# **LOCAL IMPACT REPORT**

**APPLICATION BY RAMPION EXTENSION DEVELOPMENT  
LTD FOR AN ORDER GRANTING DEVELOPMENT CONSENT  
FOR THE RAMPION 2 OFFSHORE WIND FARM**

**28 February 2024**

Figure 15.98
 Viewpoint 8: Brighton sea front promenade

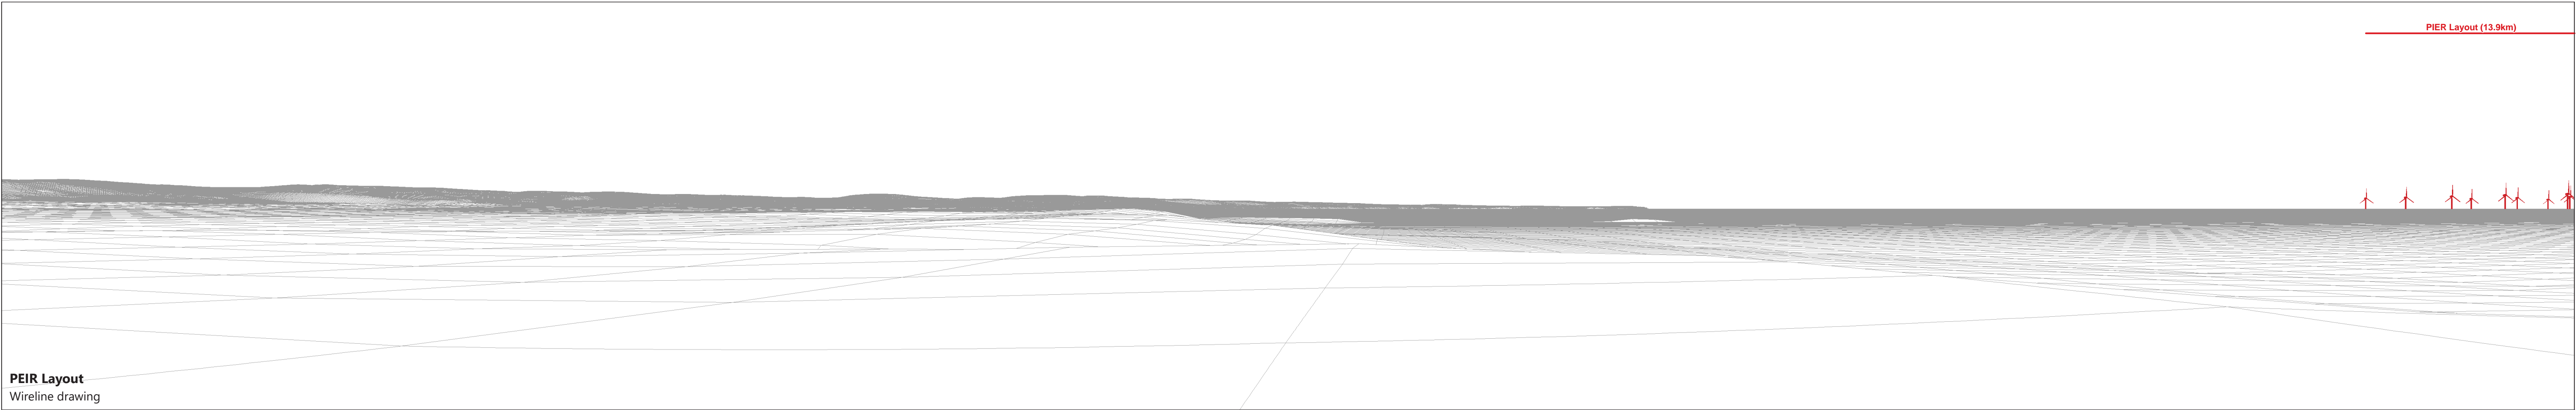
- 4.2 We are pleased to note the reduction in impact on the city when compared with the scheme proposed at the PEIR stage (figure 15.98 of the Seascape, Landscape and Visual Impact Assessment (SLVIA)).
